HUNTER INDOOR SPORTS CENTRE (SSD-65595459) - 24 WALLARAH ROAD & 2 MONASH ROAD NEW LAMBTON

I refer to the Department of Planning, Housing and Infrastructure's (DPHI) request of 18 August 2025 via the NSW Major Projects Portal inviting City of Newcastle (CN) to provide advice, including any recommended conditions of consent, on the 'Response to Submissions and Amendment Report' (Aug 2025)(RSAR) by Urbis Ltd for the State Significant Development Application (SSD-65595459) for the above development.

Figure 1: Proposed Hunter Indoor Sports Centre

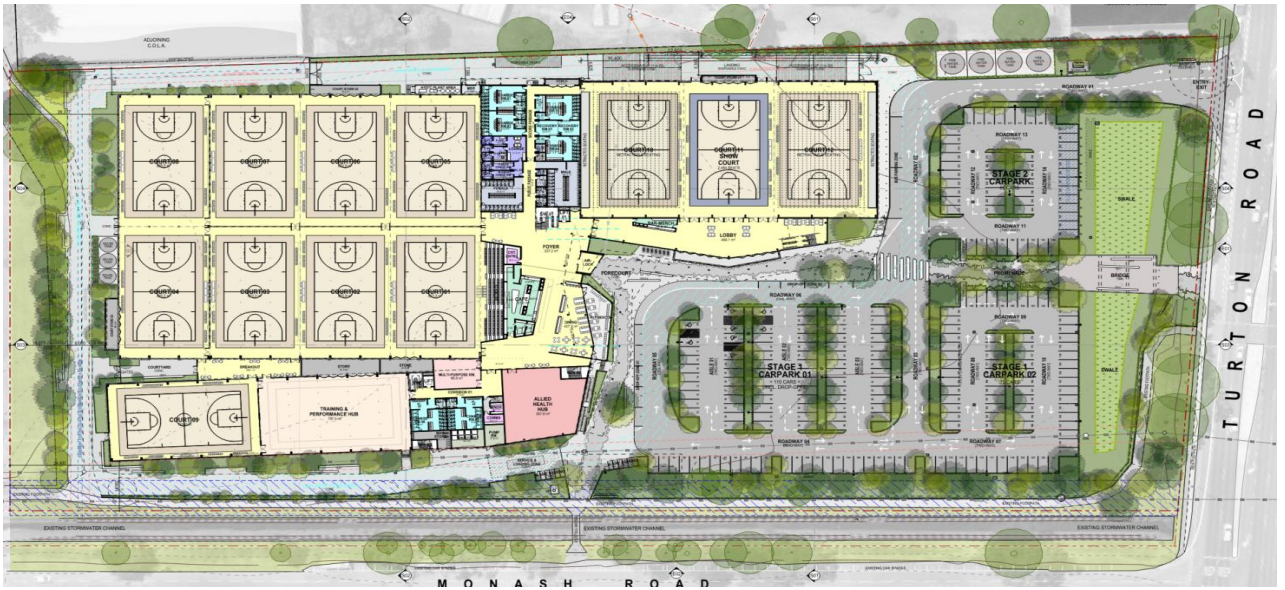
We further note a key design amendment as identified on plan 'RtS Site Plan Revisions' of EJE (Item 10) and in the RSAR (p2) is a reduction in landscape elements along the southern boundary of the site, "*...to allow space for future pedestrian/cycleway expansion, aligning with the City of Newcastle's strategic vision for the precinct.*" However, this statement appears to be inconsistent with the other submitted documentation such as the Landscape Masterplan - All Stages of Terras Landscape Architects, as well as overall view plans and illustrations which show landscaping in this location.

Any future plans to expand the pedestrian/cycleway along Ker-rai Creek (identified as an 'existing drainage corridor' on the submitted plans) will not be precluded by landscaping in this location. It is recommended the applicant be required to reinstate the proposed landscaping in this location as it will provide benefits to southern neighbours in terms of visual amenity, as well as enhanced biodiversity along Ker-rai Creek, supporting CN's blue-green grid initiative, an important outcome of the Newcastle Environment Strategy.

FIGURE C1 – NRZ/SRZ DIAGRAM [BASE SURVEY SOURCE: DE WITT CONSULTING]

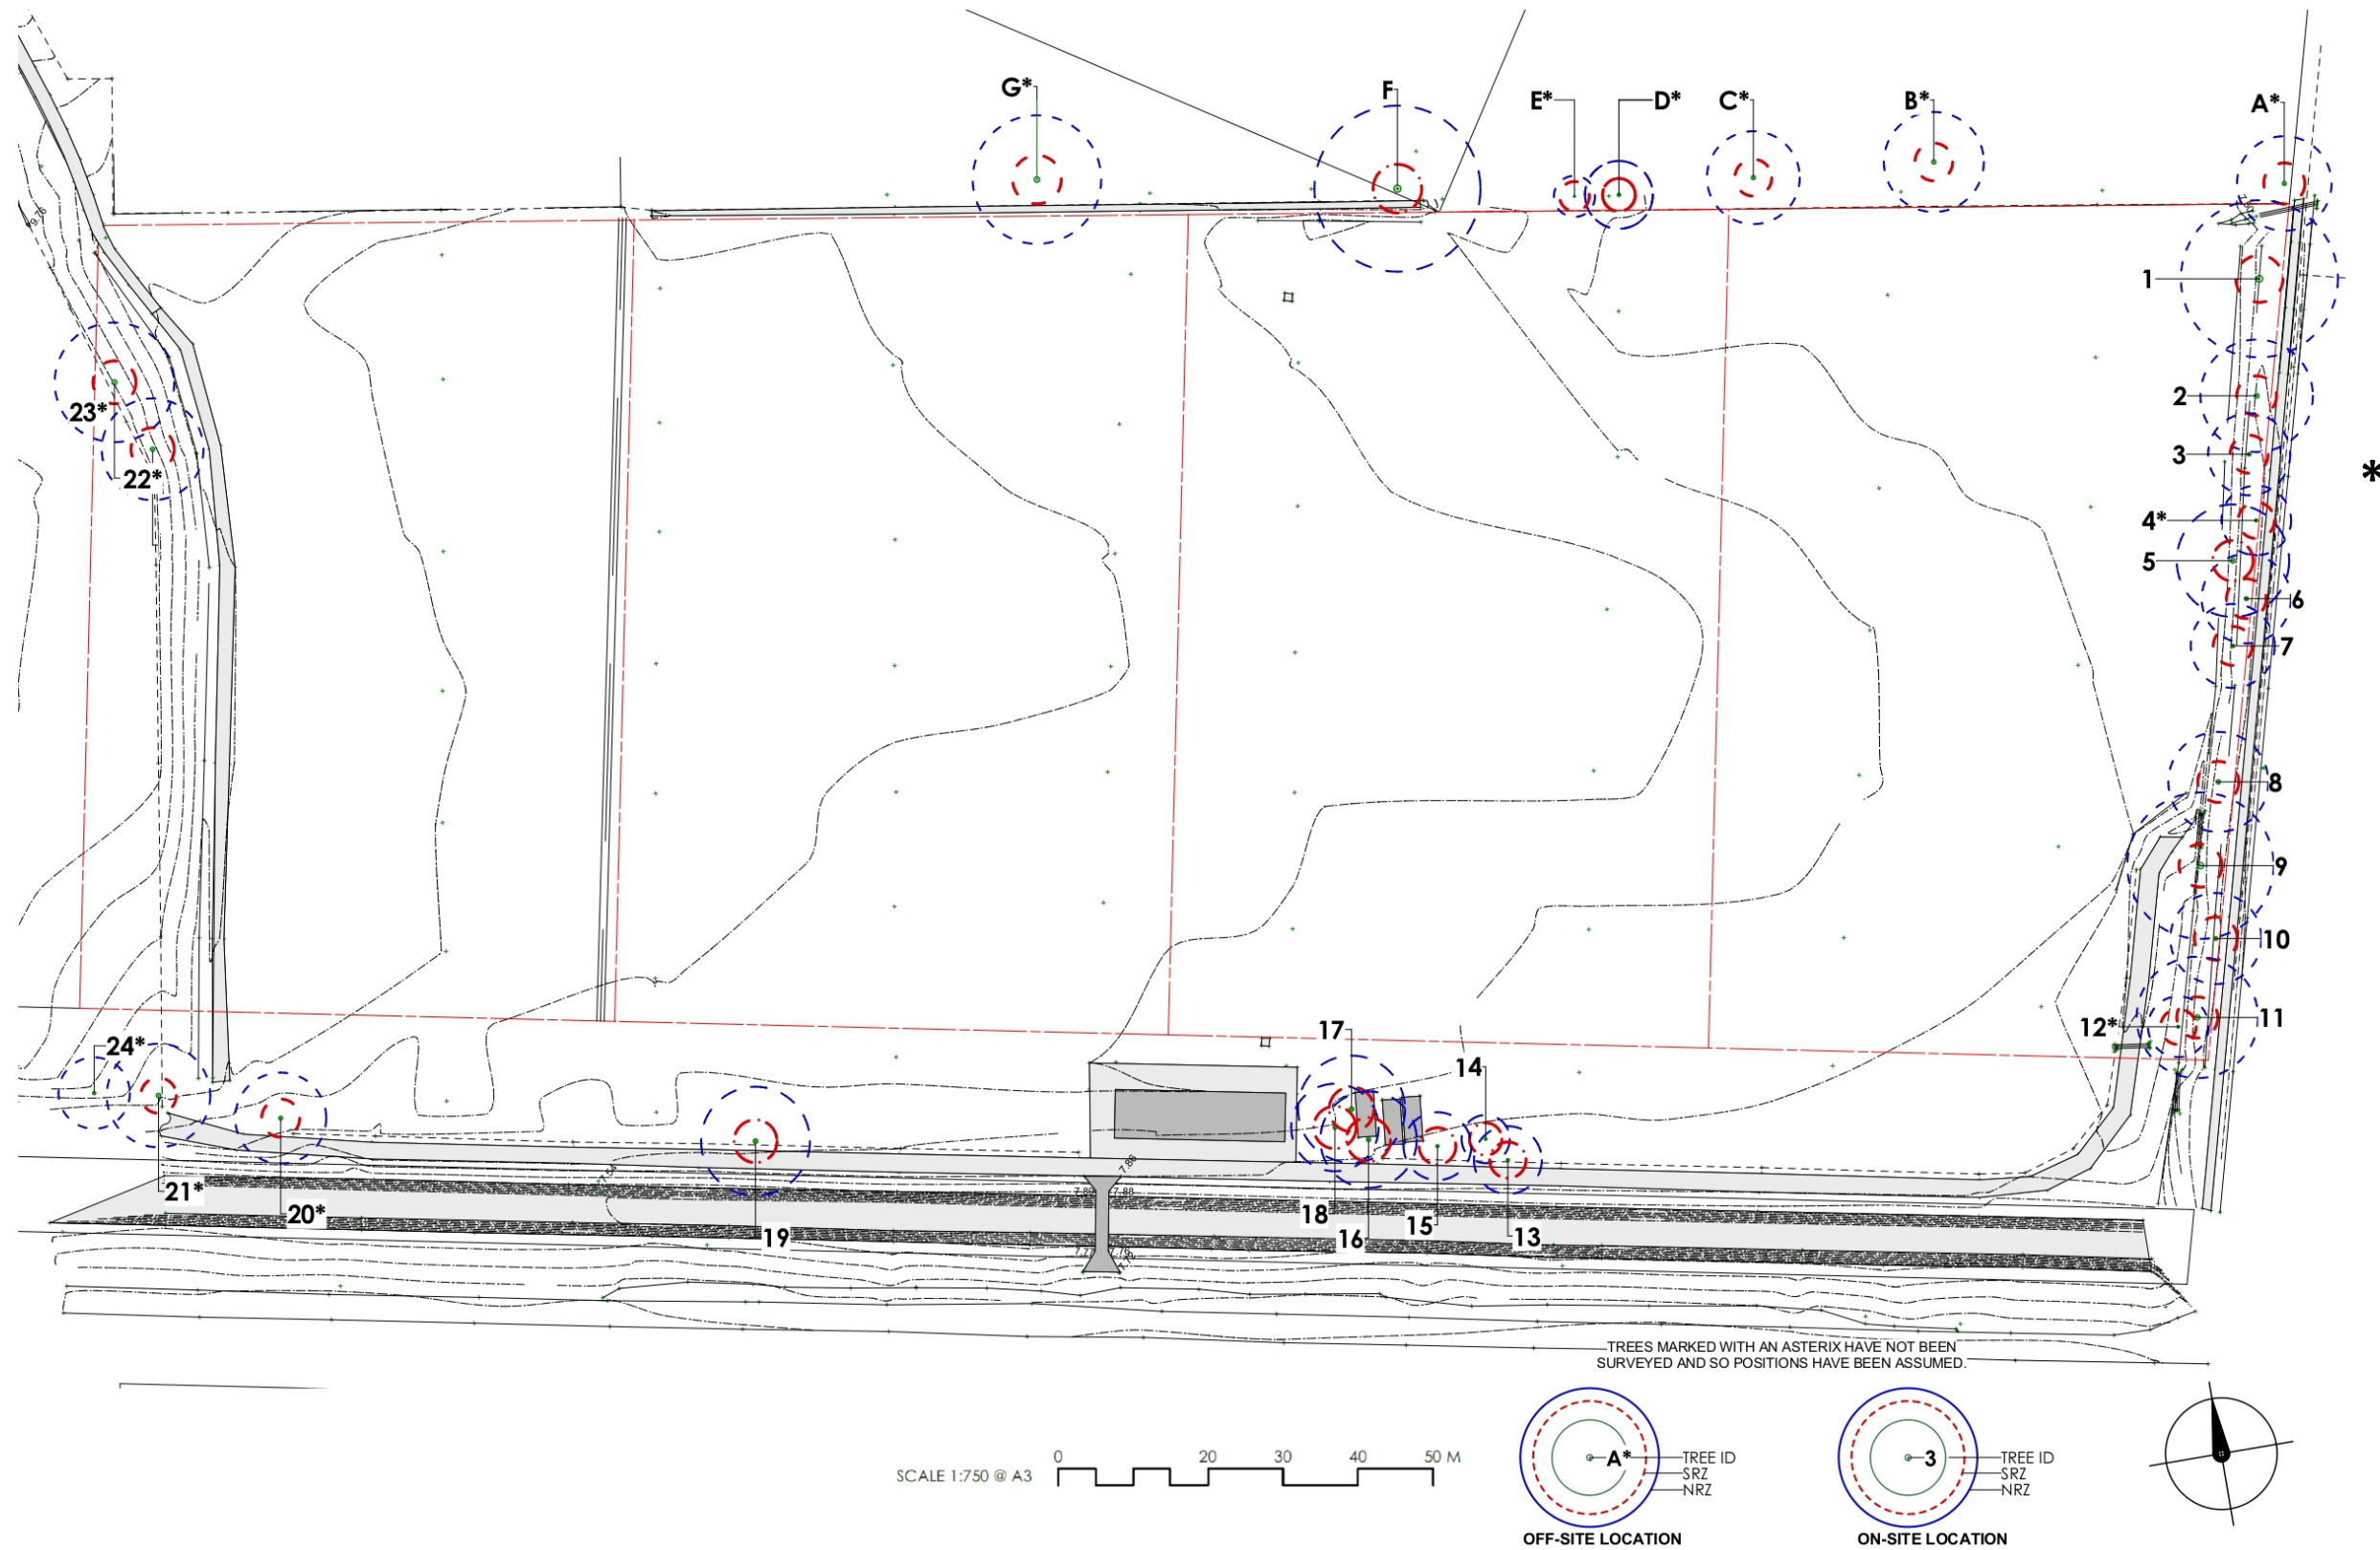
CN notes the AIA is inconsistent in its identification of the locations of Trees 1 & 2. While the above recommendations refer to the trees as being off-site, Figure 4:Tree Location & Notation identifies the trees as being on site, with their locations confirmed by survey. We also note that contrary to the above recommendations, the provision of compensatory

planting is based only on the removal of Trees 17-20. Further compensatory planting is therefore required for the proposed removal of Trees 1 & 2.
